CITY OF ALBUQUERQUE

June 9, 2017

Re: Apartment for Ahmet Tiryaki
5501 Bell Ave. SE
Traffic Circulation Layout
Architect's Stamp 6-1-17 (L18D082)

1 TCL PLAN
Scale: 1" = 10'-0"

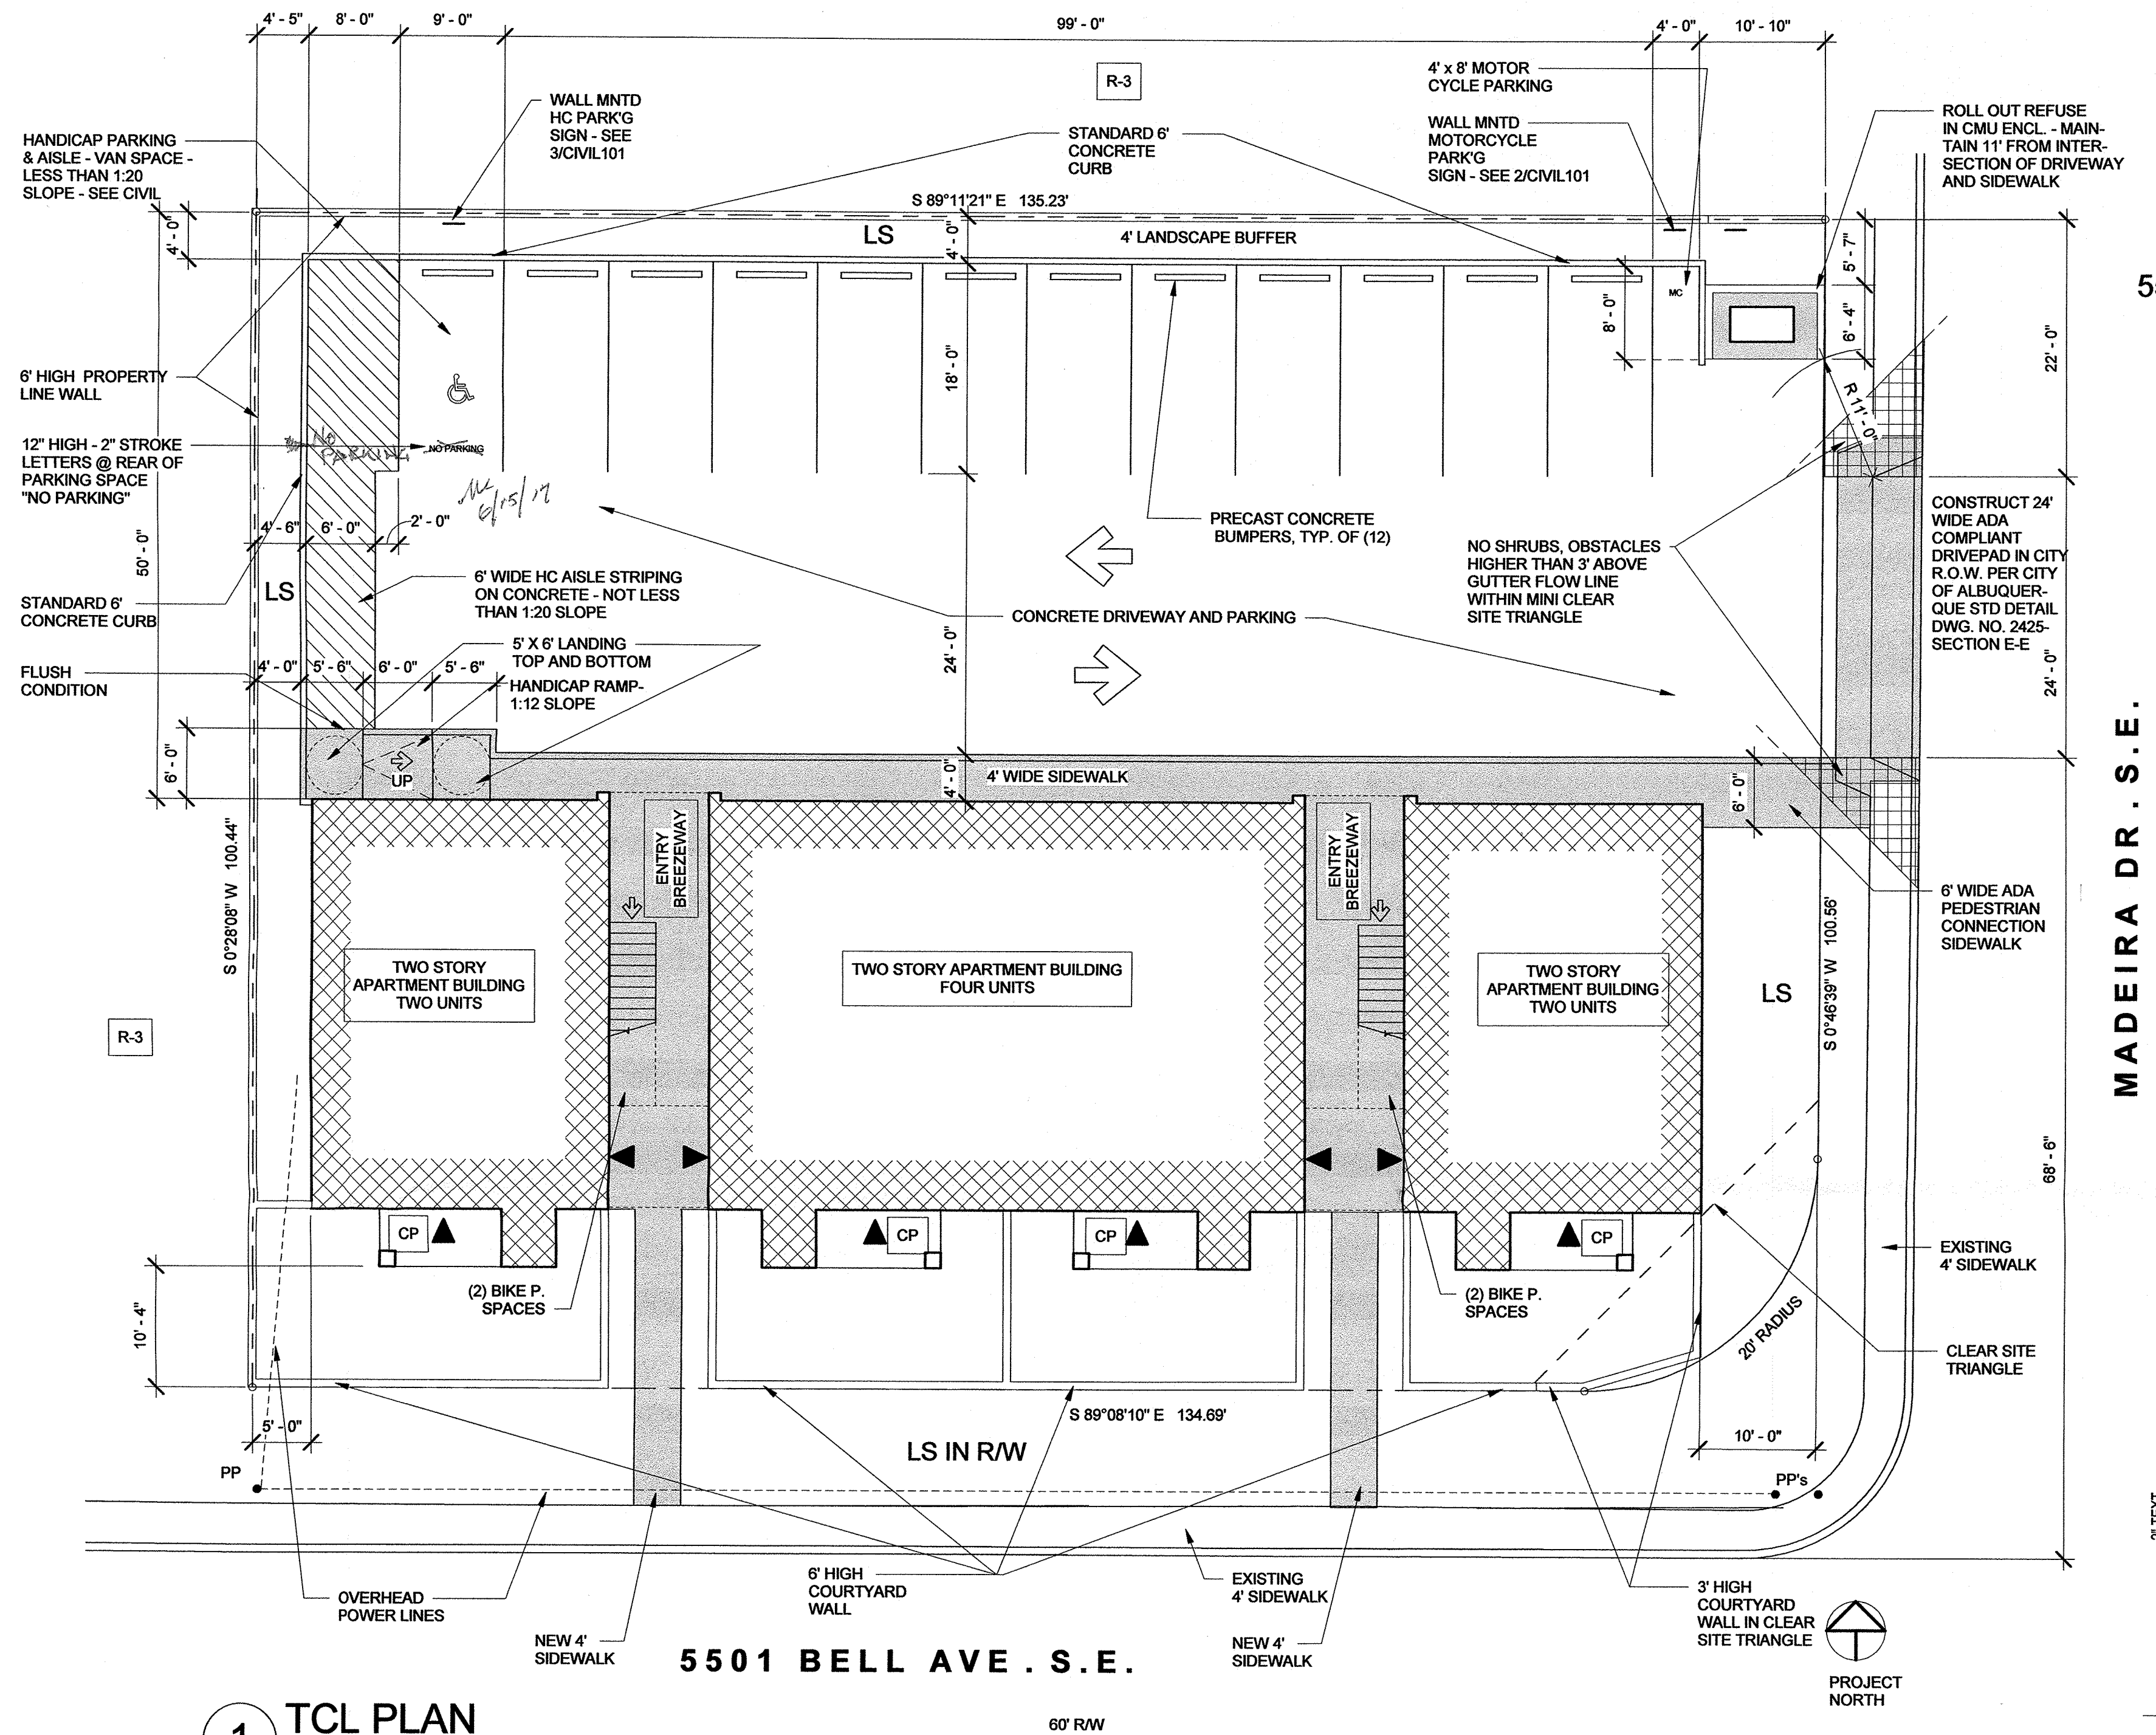
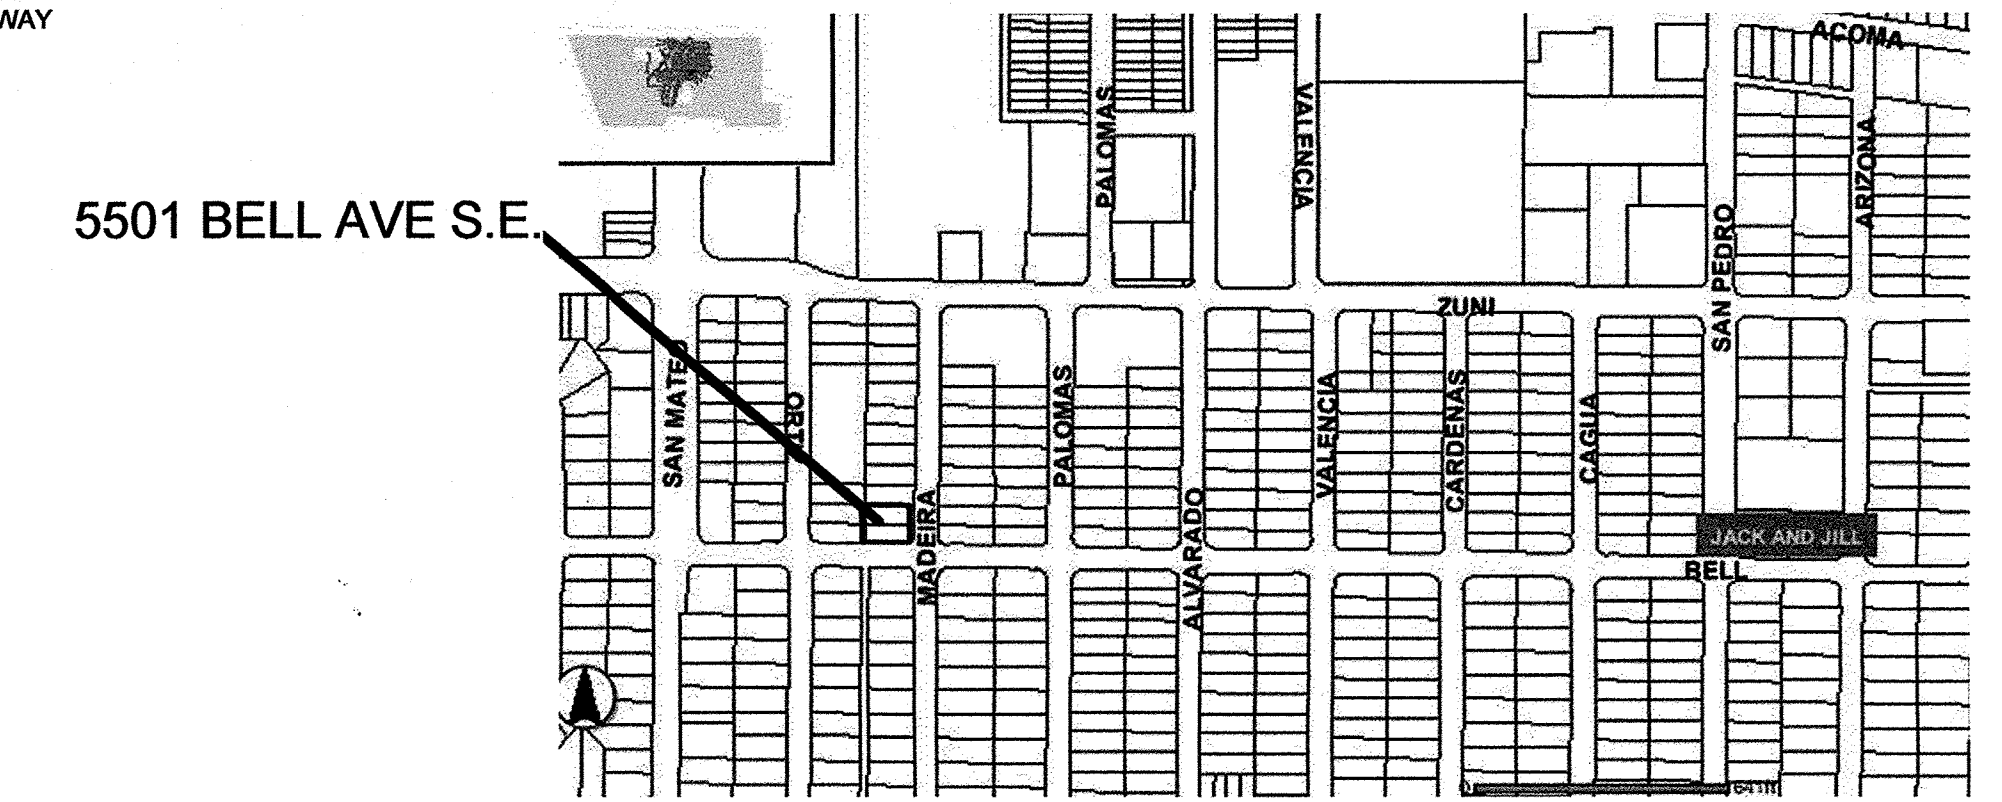
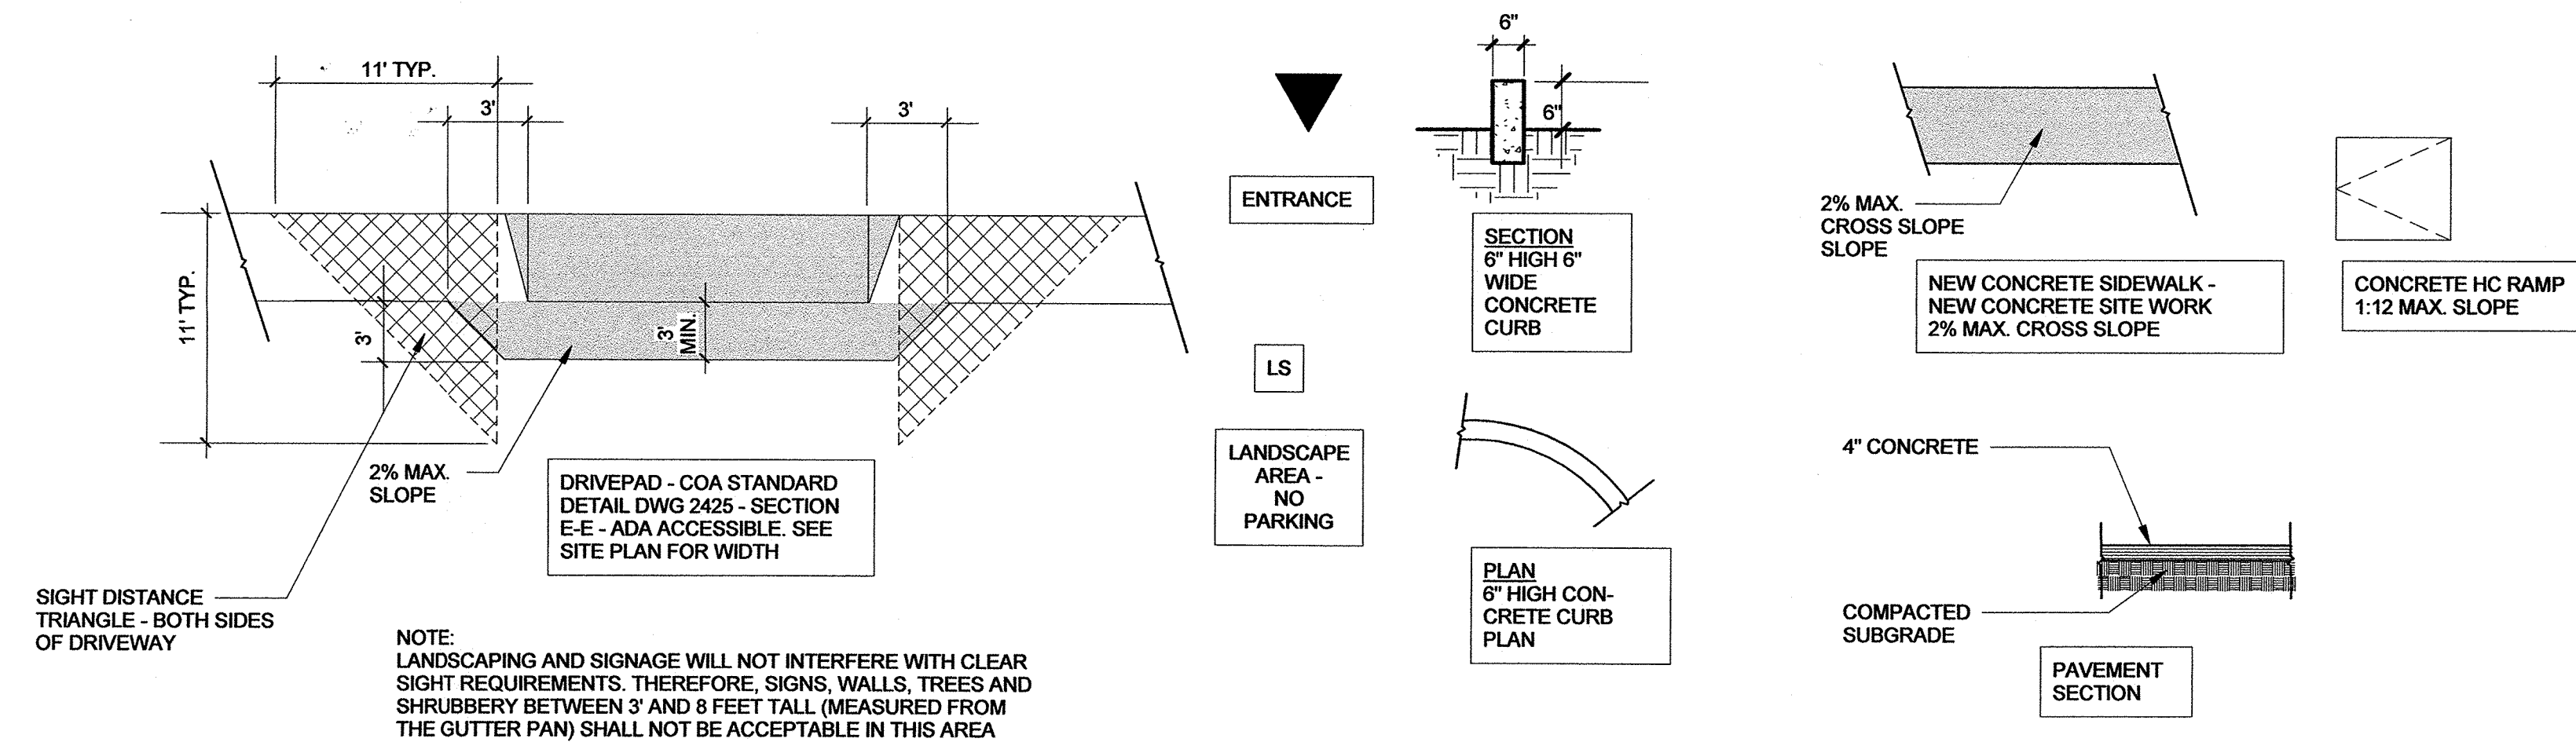
1. The ADA access aisles shall have the words **"NO PARKING"** in capital letters, each of which shall be at least one foot high and at least two inches wide, placed at the rear of the parking space so as to be close to where an adjacent vehicle's rear tire would be placed. (66-1-4.1.B NMSA 1978)
2. Please relocate the Motorcycle parking spot. Vehicle and pedestrian/wheelchair conflicts should be avoided as much as possible.
3. Per DPM, a 6 ft. wide ADA accessible pedestrian pathway is required from the HC parking stall access aisles to the building entrances. Please clearly show this pathway and provide details.
4. Parking spaces should be 9.5 feet for the access aisle to be 22 feet.
